Project Name: Honor Charter Academy

Date: 06-26-2026

PCD File No. PPR2615

OFFSITE STORM PLAN 1

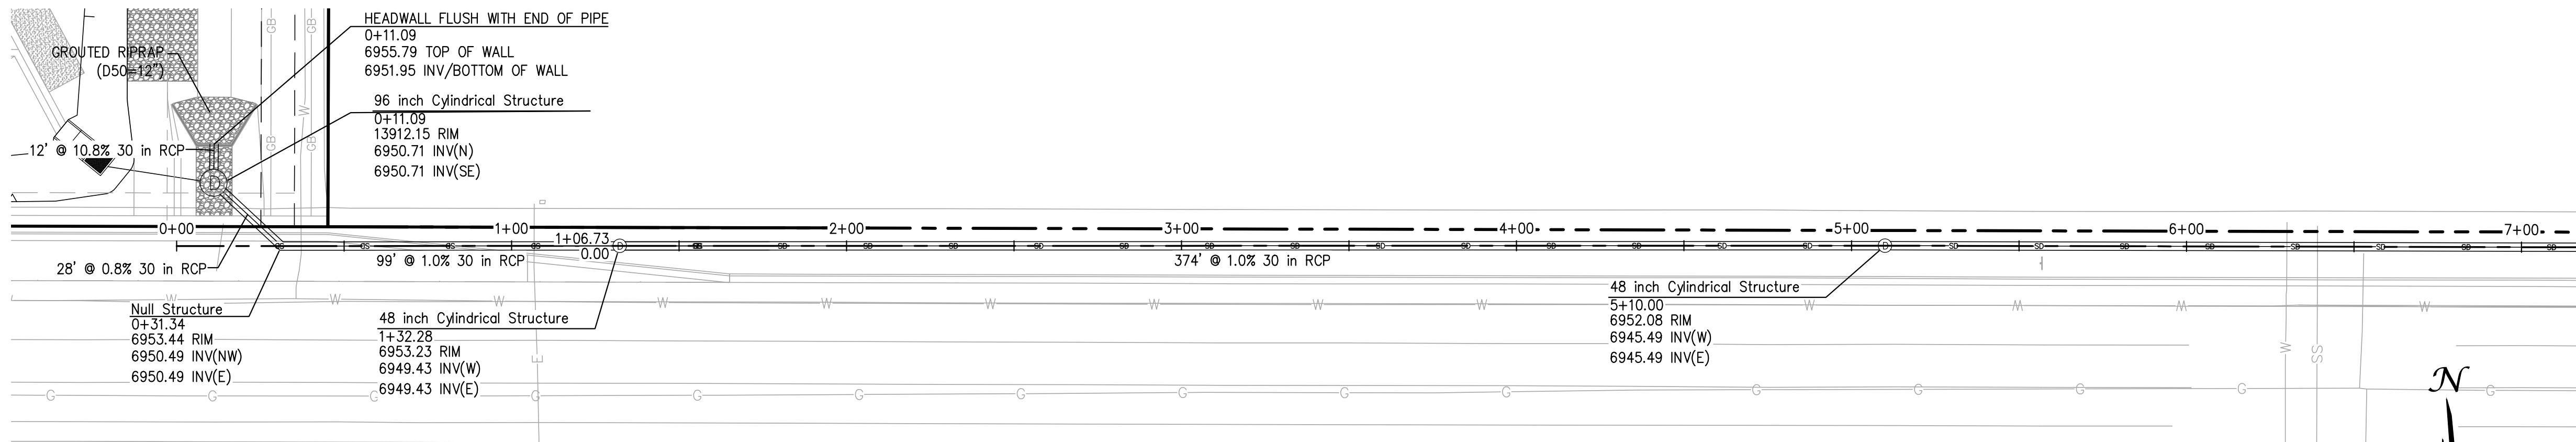
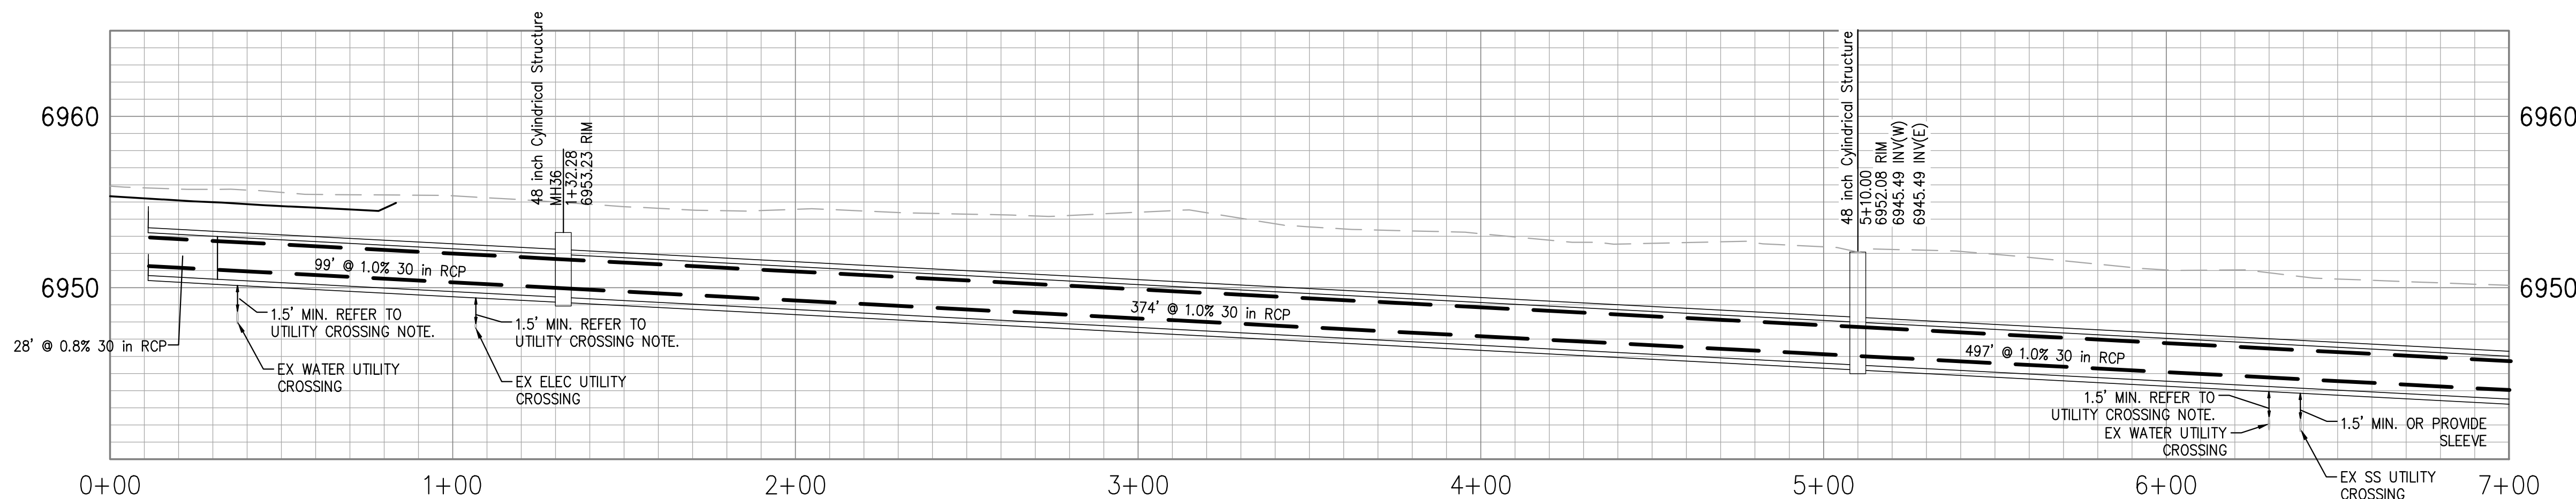
Description	Quantity	Units	Unit Cost		Total	(with Pre-Plat Construction)	
						% Complete	Remaining
TAIT Response: 30" RCP length has been revised				=	\$ -		\$ -
This number should be closer to 2,000. Please revise.				=	\$ -		\$ -
[insert items not listed but part of construction plans]				=	\$ -		\$ -
STORM DRAIN IMPROVEMENTS							
Concrete Box Culvert (M Standard), Size (W x H)		LF		=	\$ -		\$ -
18" Reinforced Concrete Pipe		LF	\$ 111.00	=	\$ -		\$ -
24" Reinforced Concrete Pipe		LF	\$ 161.00	=	\$ -		\$ -
30" Reinforced Concrete Pipe	5213.	LF	\$ 167.00	=	\$ 870,571.00		\$ 870,571.00
36" Reinforced Concrete Pipe	438.	LF	\$ 191.00	=	\$ 83,658.00		\$ 83,658.00
42" Reinforced Concrete Pipe		LF	\$ 275.00	=	\$ -		\$ -
48" Reinforced Concrete Pipe		LF	\$ 349.00	=	\$ -		\$ -
54" Reinforced Concrete Pipe		LF	\$ 465.00	=	\$ -		\$ -
60" Reinforced Concrete Pipe		LF	\$ 476.00	=	\$ -		\$ -
66" Reinforced Concrete Pipe		LF	\$ 550.00	=	\$ -		\$ -

SIGNAGE AND STRIPING PLAN

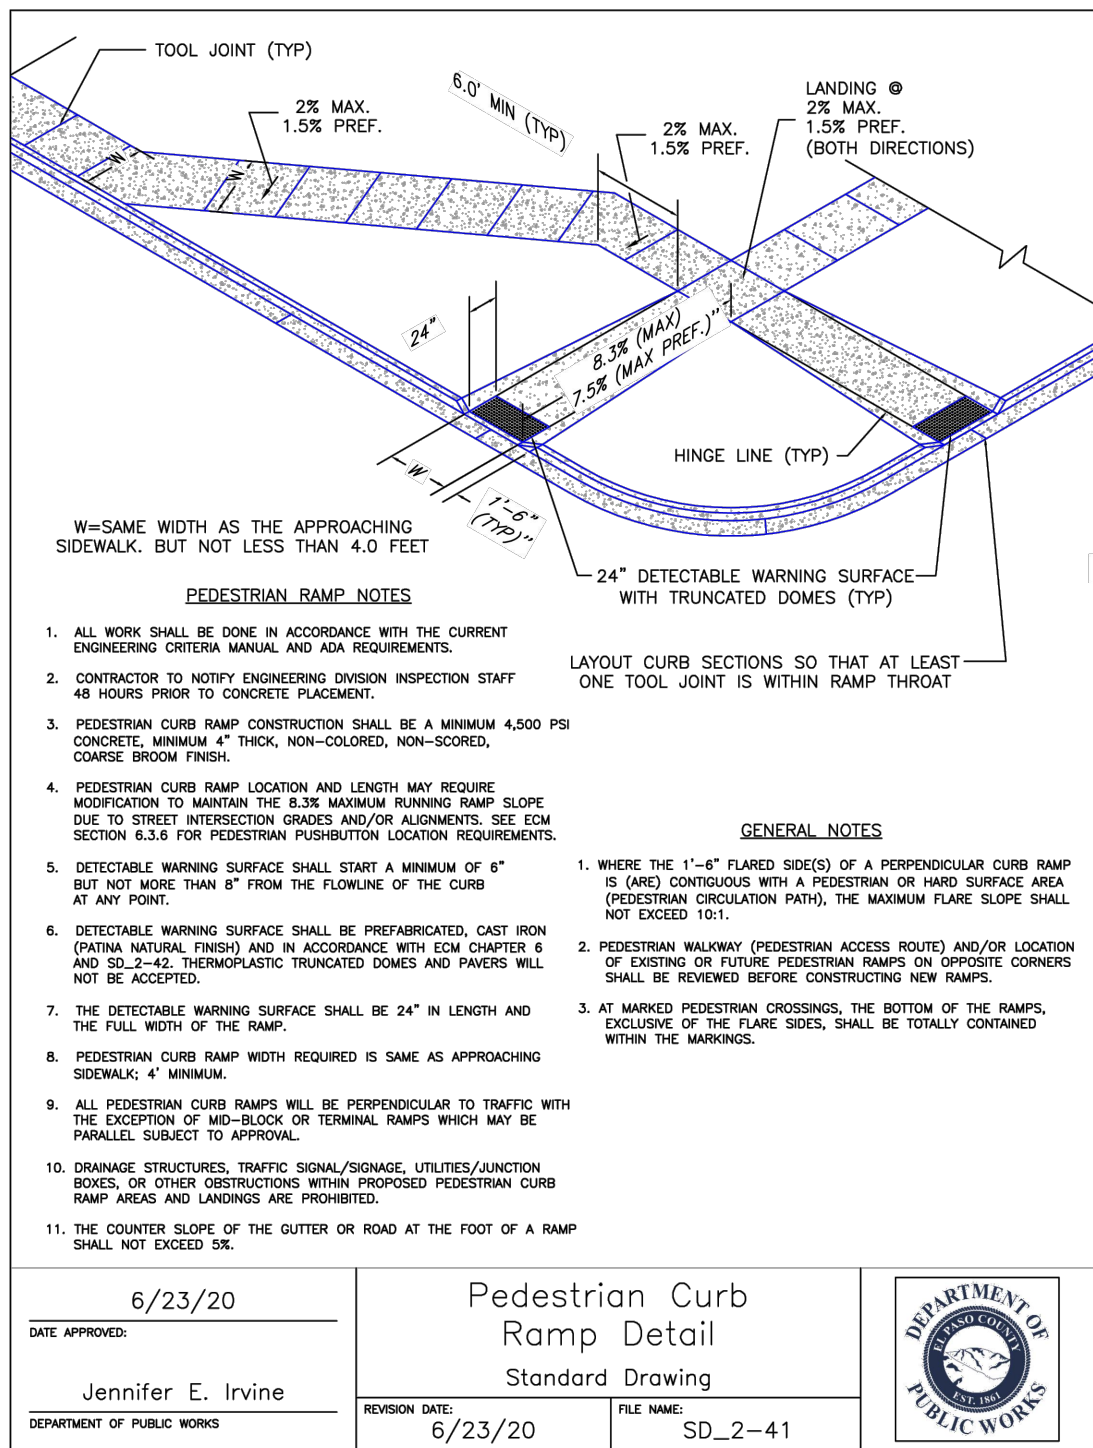
Include all signs shown on offsite signage and striping plan.
